SUBJECT: BRES2405-0073
BUILDING RESIDENTIAL

Here are the results of all Inspections located at **1385 ATKINS RD:**

Inspection Type: ROUGH IN
Scheduled Date/Time: 12/27/2024
Completed Date/Time: 12/27/2024
Inspector: Justin Ryan McLeod
Result: DISAPPROVED

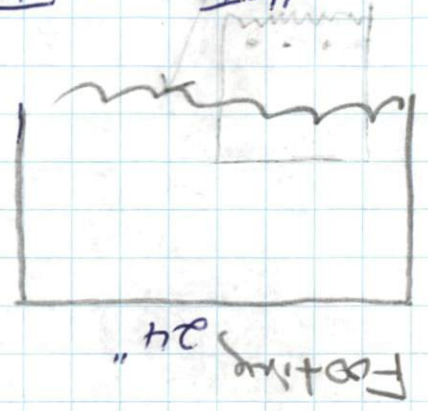
Inspection Type: FOOTING
Scheduled Date/Time: 10/9/2024
Completed Date/Time: 10/9/2024
Inspector: Daniel L Floyd
Result: DISAPPROVED
Remarks:
Notes: Inspector TSG changed the inspection assignment from TSG to DLF
Plumbing sleeves must be of the same material and 1 nominal size larger and sealed on both sides

Bed Room Expansion

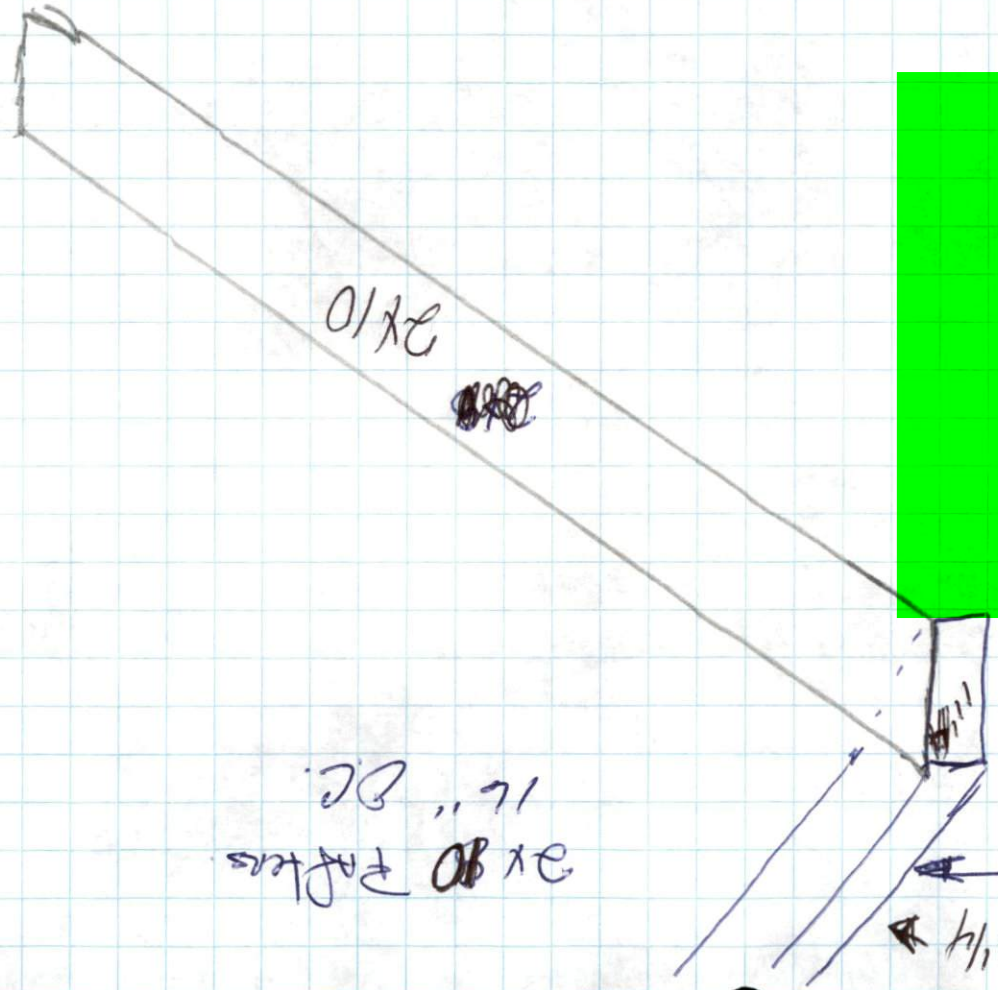
Notes: 1. Where short wall was removed in bedroom 2 ceiling joists are not bearing anymore. 2. Fire block top plate penetrations 3. Hanger at skylight 4. Air barrier above lvl beam. 5. Add stud beside 5 stud column where original stud is over notched in two places. 6. Window tape not installed.
